From: Ellie Thornhill
Sent: 28 November 2024 11:54
To: DC Admin
Subject: FW: Planning Application 2023/62/91212/W - Land off Bankfield Drive, Holmbridge

From:
Sent: 19 September 2024 14:33
To: Ellie Thornhill <Ellie.Thornhill@kirklees.gov.uk>
Subject: Planning Application 2023/62/91212/W - Land off Bankfield Drive, Holmbridge

Further to the viability assessment report that has recently been submitted for the above planning application, we would like to draw your attention to our main concerns in relation to the plans for this development particularly as we feel that twenty one houses is far too many for this plot and the finished build will be visually unappealing. Due to over intensification of the site, the plots are very small and there will be little privacy for the home owners. The houses are a selection of detached, semi-detached and terraced which means they are not in keeping with the existing houses on the estate which are all detached and also include a number of bungalows. Only a handful of the houses on the plans have garages and although each property has two designated parking spaces these are not all in close proximity to the houses therefore we envisage there will

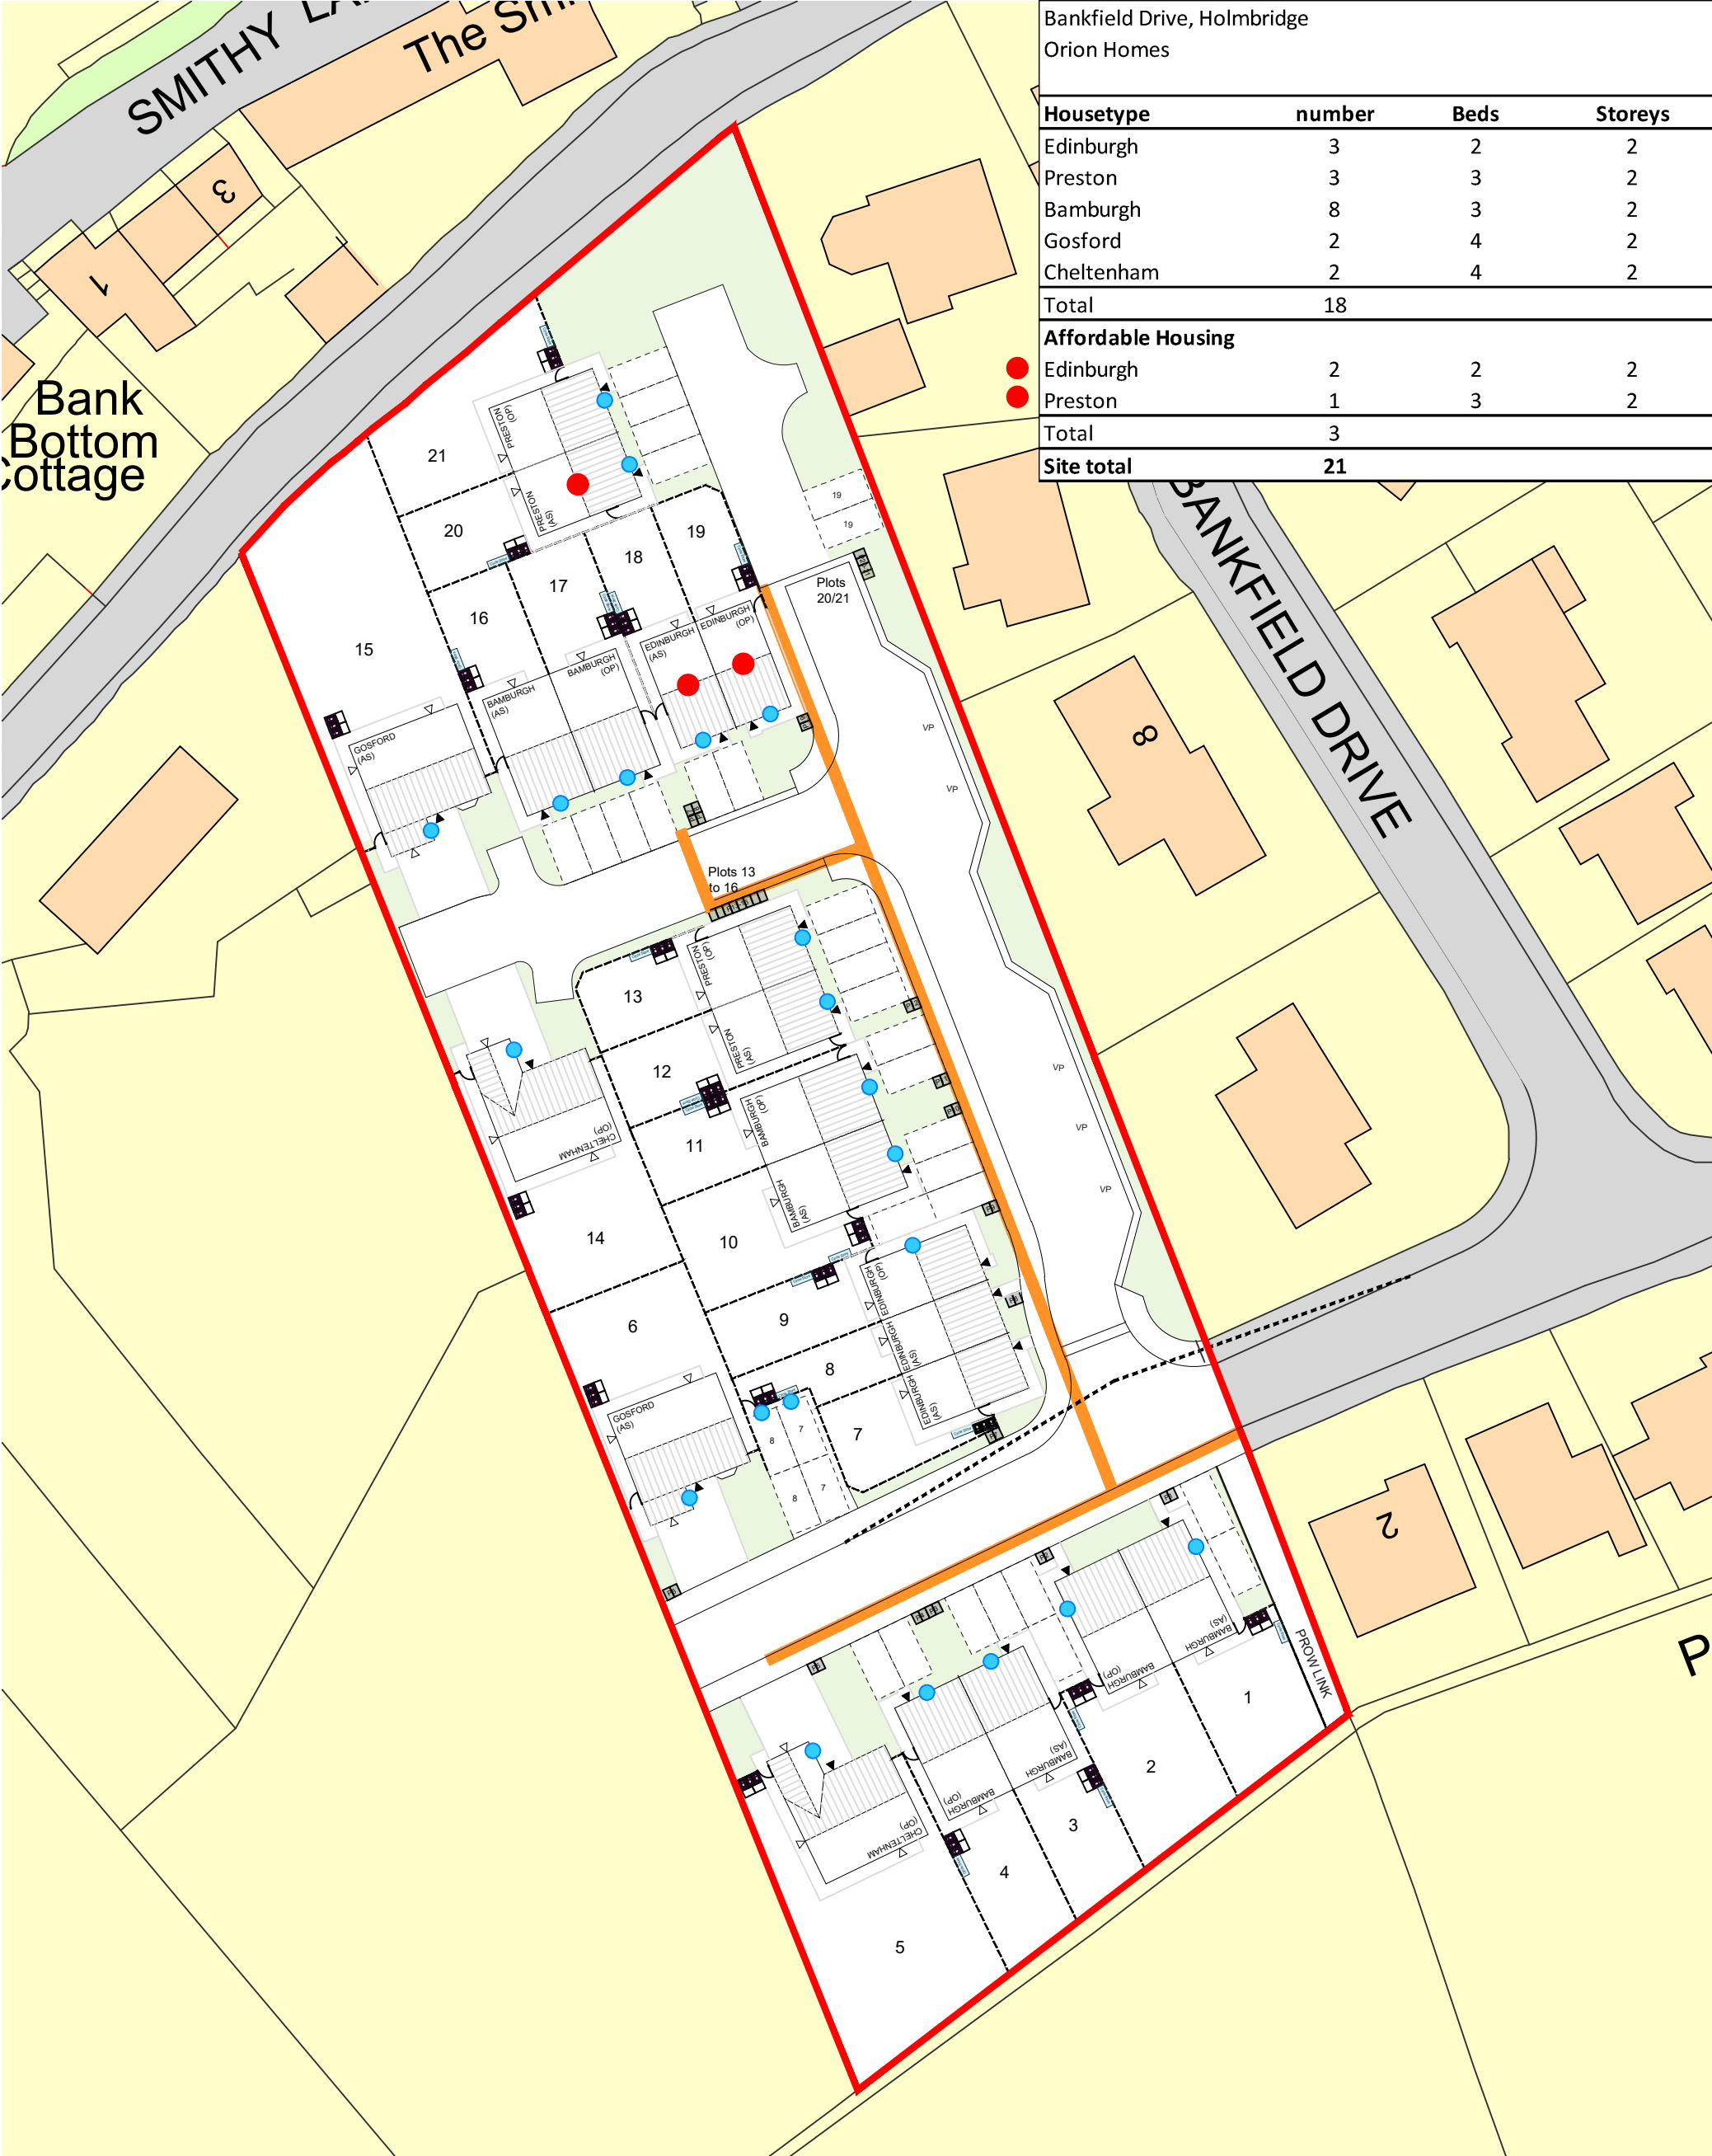
Finally, as previously mentioned, plot one is far too close to our house, 2 Laithe Avenue as our front door and two windows of habitable rooms are on the side elevation and will overlook the new development. We will lose an unacceptable amount of privacy and light. The separation distance on the plans does not meet the minimum requirements of the Kirklees Housebuilders Design Guide 7.19 and this needs to be rectified.
